Ribble Valley Borough Council
Housing & Development Control

Application no: **3/2022/1094**

Address: **Land Adjacent to Hawthorn Cottage Slaidburn Road Newton in Bowland BB7 3EB**

Proposal: **Proposed demolition of former estate workshop and erection of a two storey detached dwelling.**

6510-002 REV

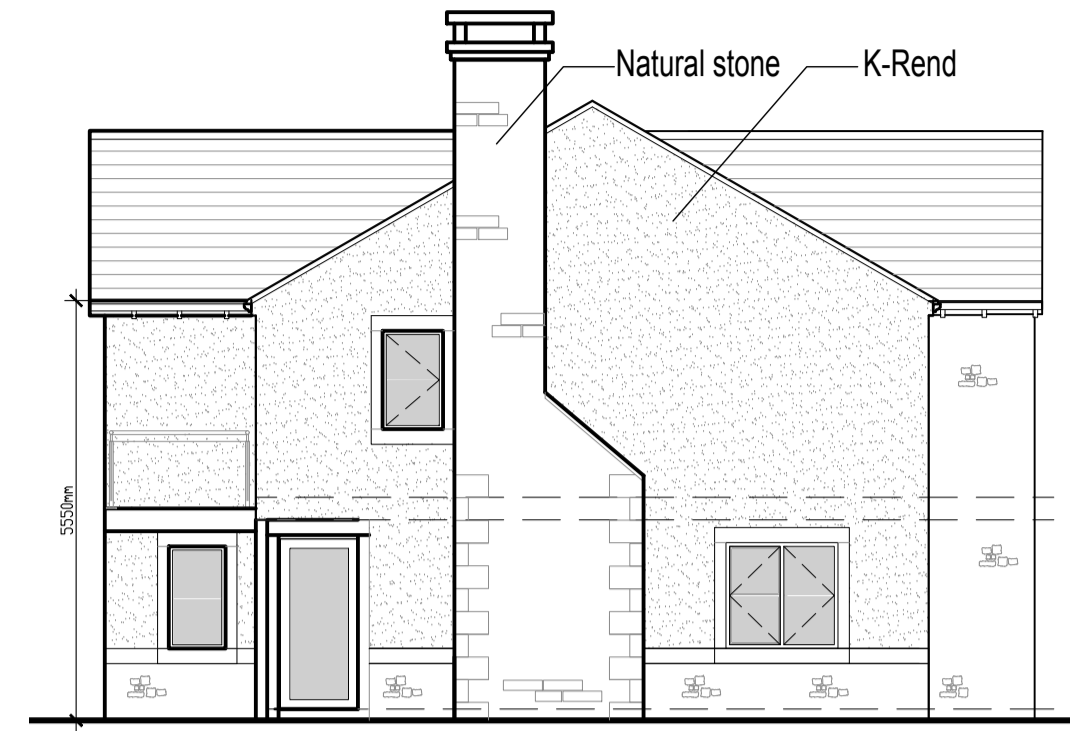
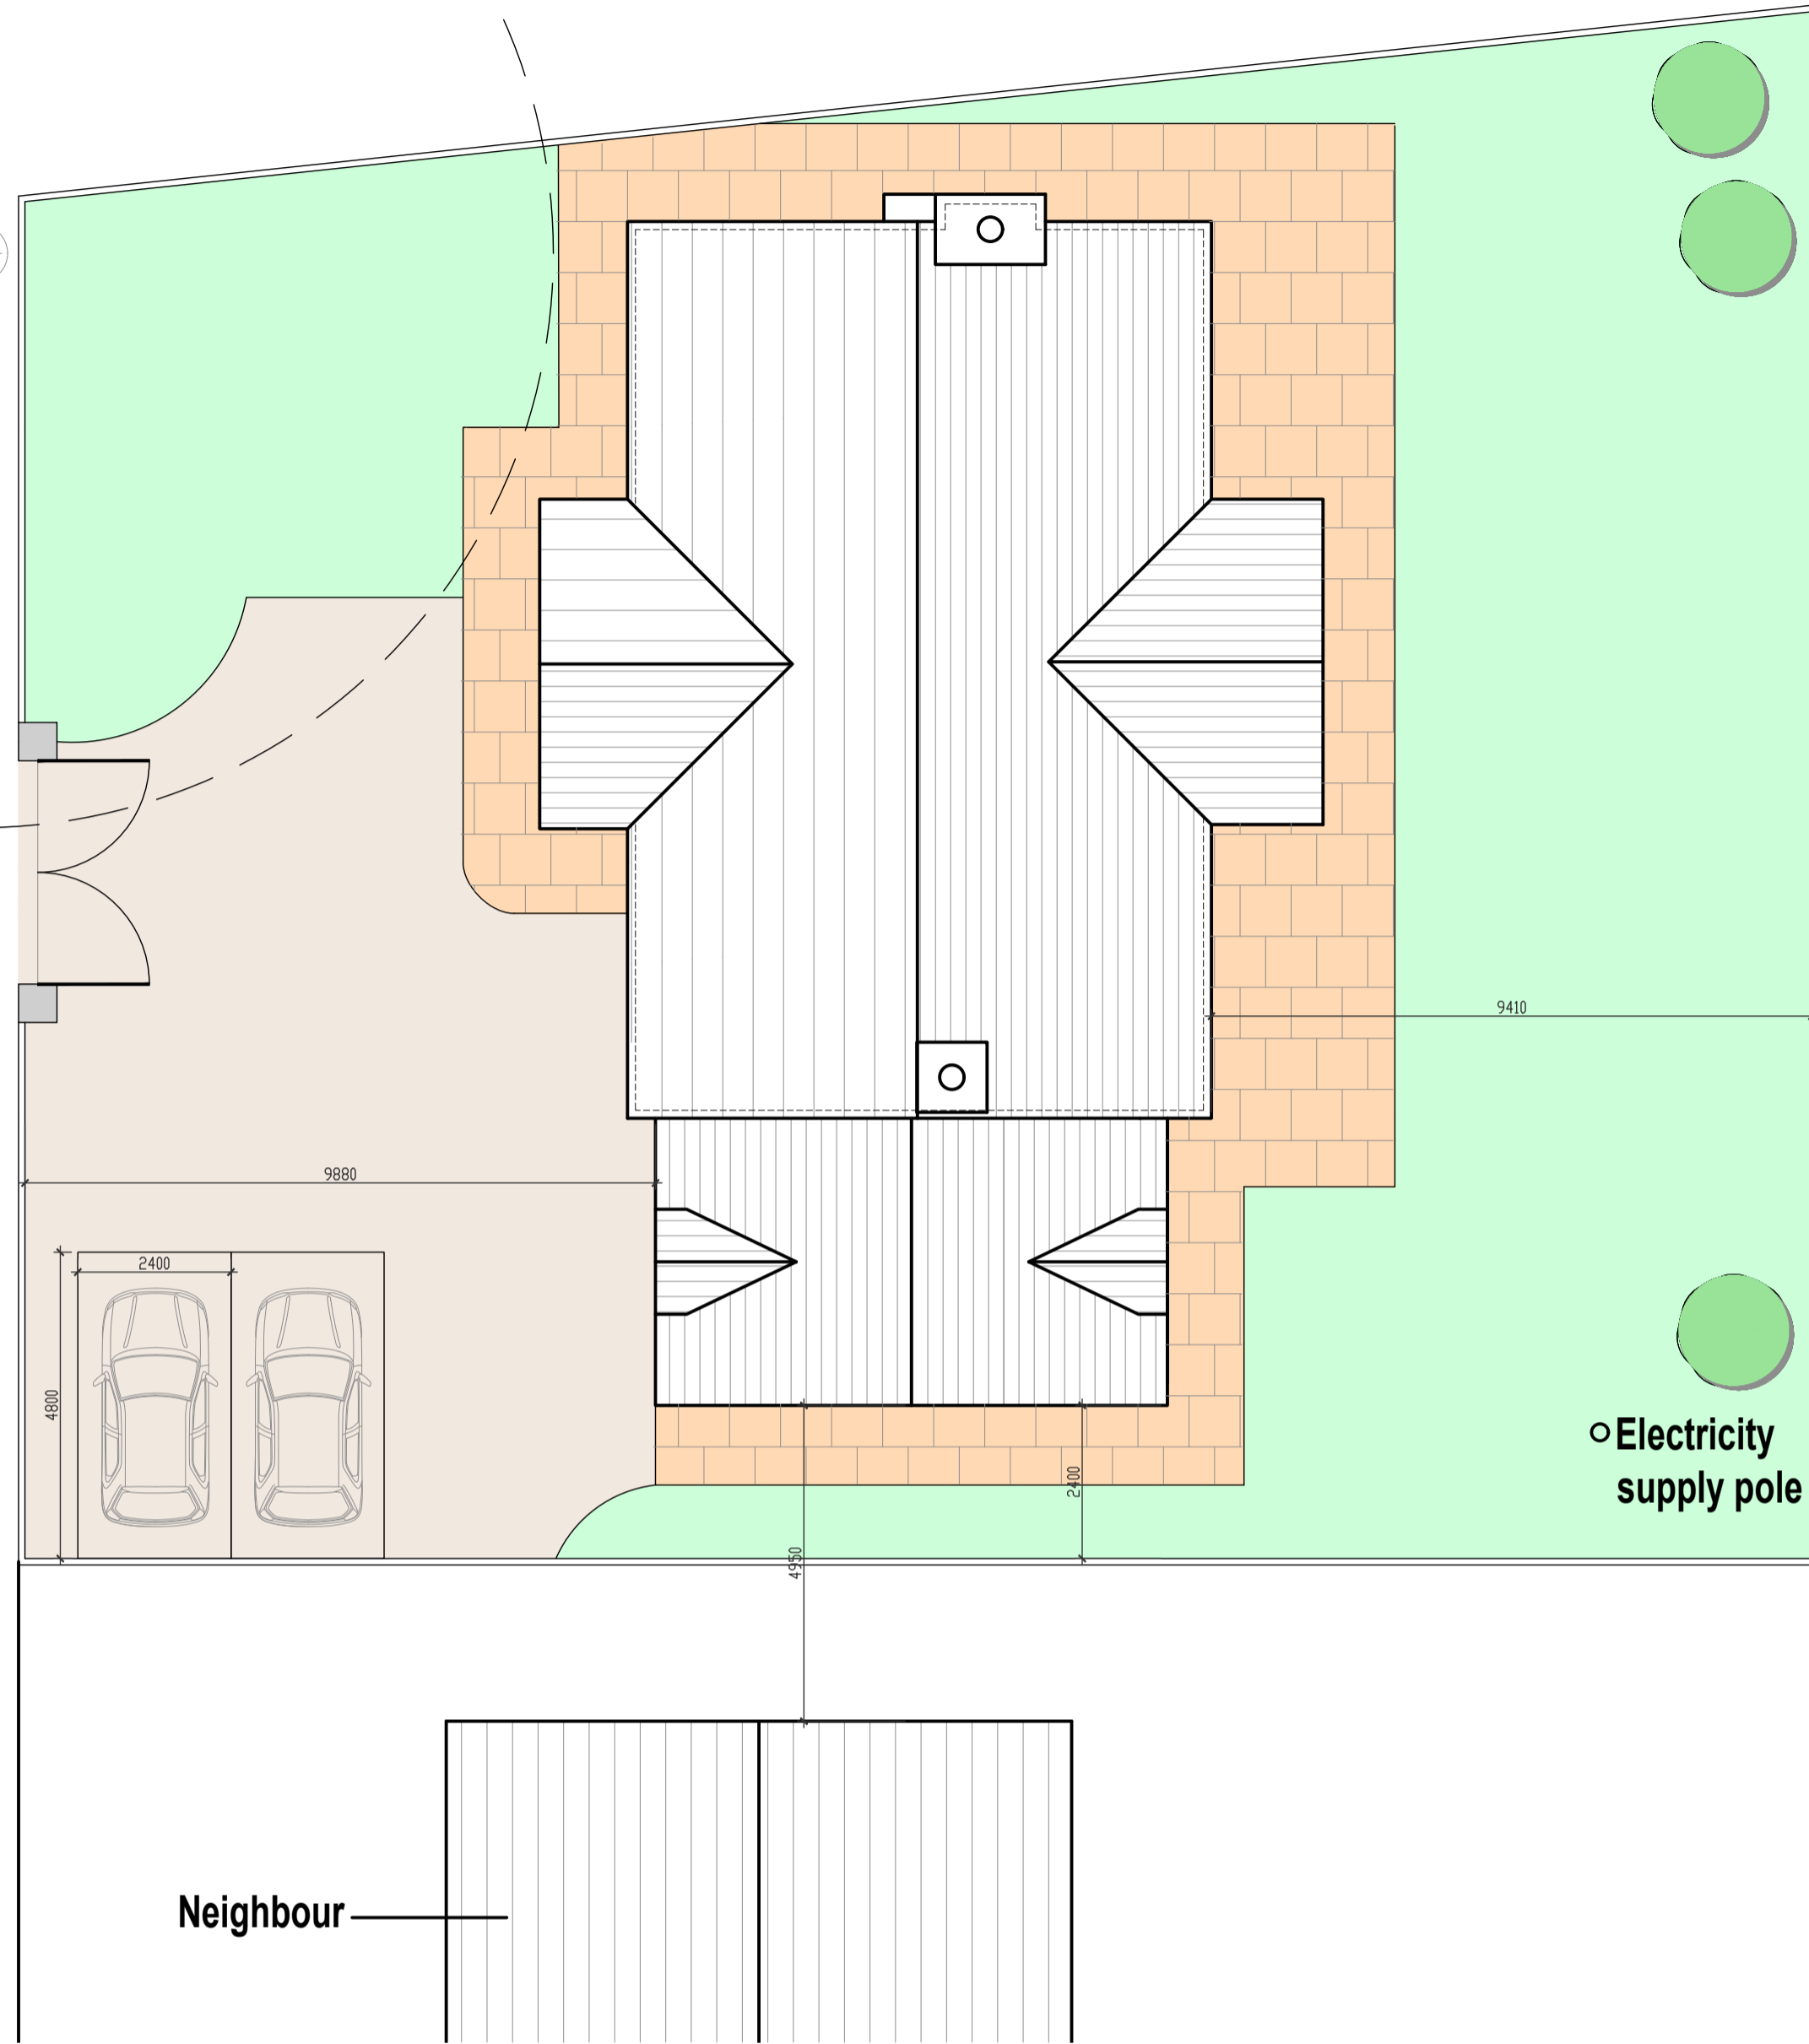
The LHA have reviewed SPA drawing number 6510-002 titled "Proposed New Self Build Dwelling" and are aware that the proposed parking arrangements complies with the LHAs parking guidance as defined in the Joint Lancashire Structure Plan.

The LHA will however condition that a minimum of one car parking space is provided to charge an electric vehicle to contribute towards sustainable travel.

2. The development hereby permitted shall not be occupied until such time as the parking and turning facilities have been implemented in accordance with SPA drawing number 6510-002. Thereafter the onsite parking provision shall be so maintained in perpetuity.

3. Prior to the first occupation the dwelling shall have an electric vehicle charging point. Charge points must have a minimum power rating output of 7kW, be fitted with a universal socket that can charge all types of electric vehicle currently.
